Our ref: AN/2023/134163/04-L01
Your ref: EN010123
Date: 2 November 2023

Application by Ecotricity (Heck Fen Solar) Limited (“the Applicant”) under the Planning Act 2008 for the Heckington Fen Solar Park Development Consent Order on land at Six Hundreds Farm, Six Hundreds Drove, East Heckington, Sleaford, Lincolnshire

Environmental Statement Chapter 9 – Hydrology, Hydrogeology, Flood Risk and Drainage [APP-062]

Figure 4.21
Central Control Building Elevation

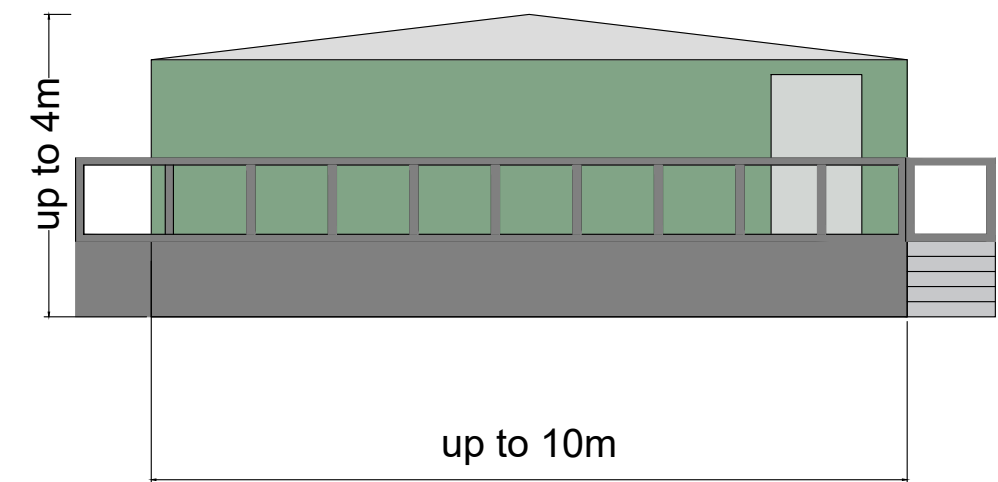
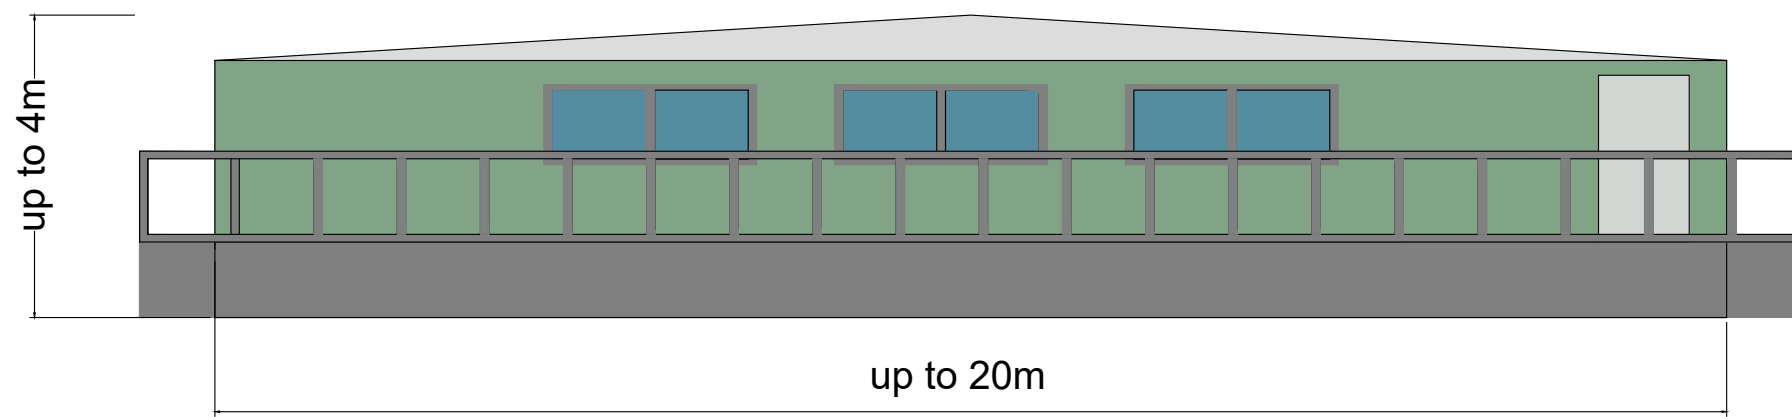
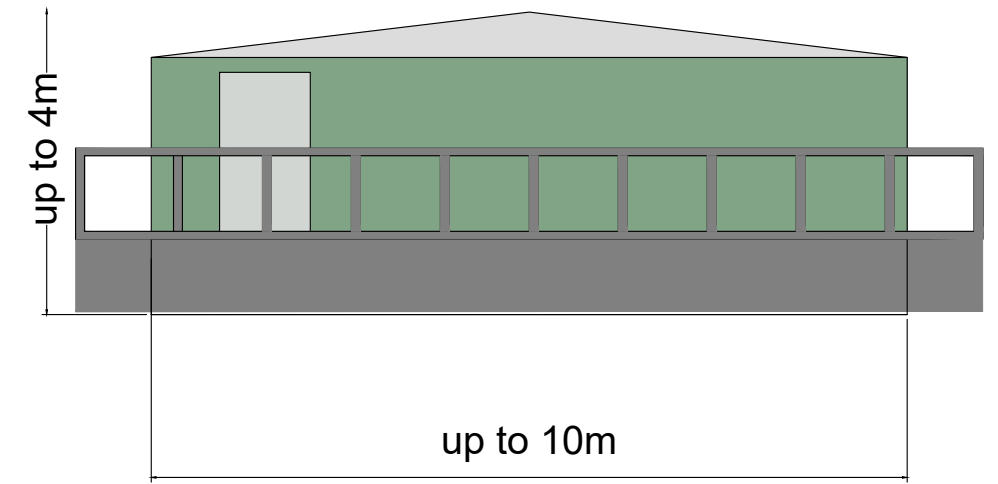
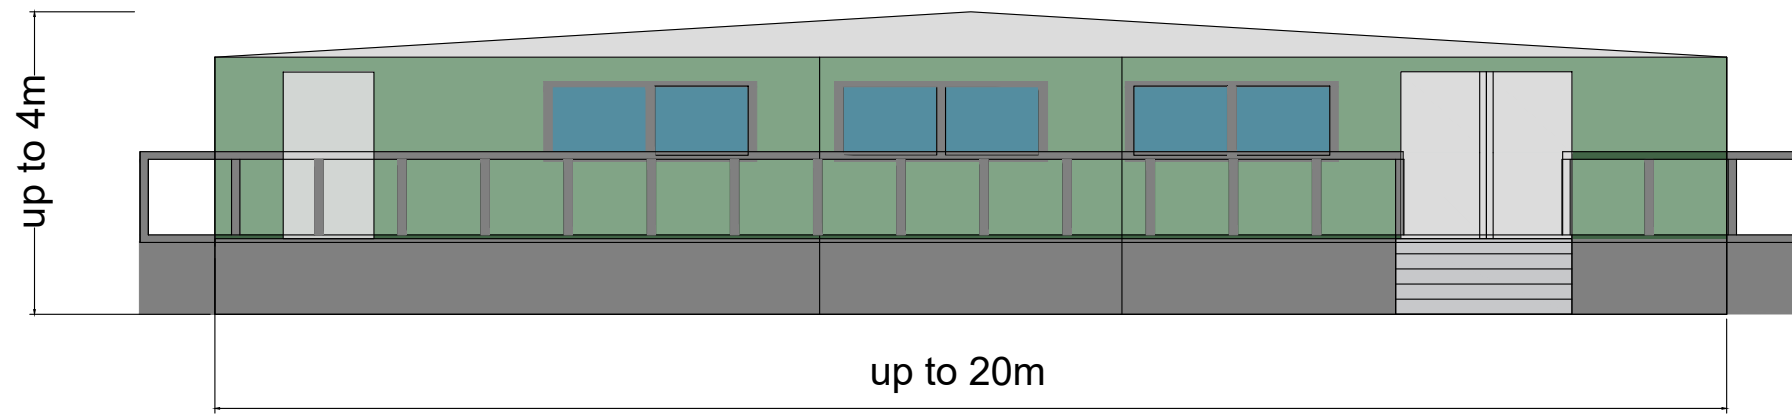
The Applicant has provided us with copies of updated drawings of the Substation Control Building Elevation (Figure 4.22, Ref: 6945_T0095_03, dated October 2023) and the Central Control Building Elevation (Figure 4.21, Ref: 6945_T0094_03, dated October 2023), which we understand will be submitted at Deadline 2. These drawings state that the finished floor level of both buildings will be at or above 2.25mAOD. Accordingly, this matter is now resolved.
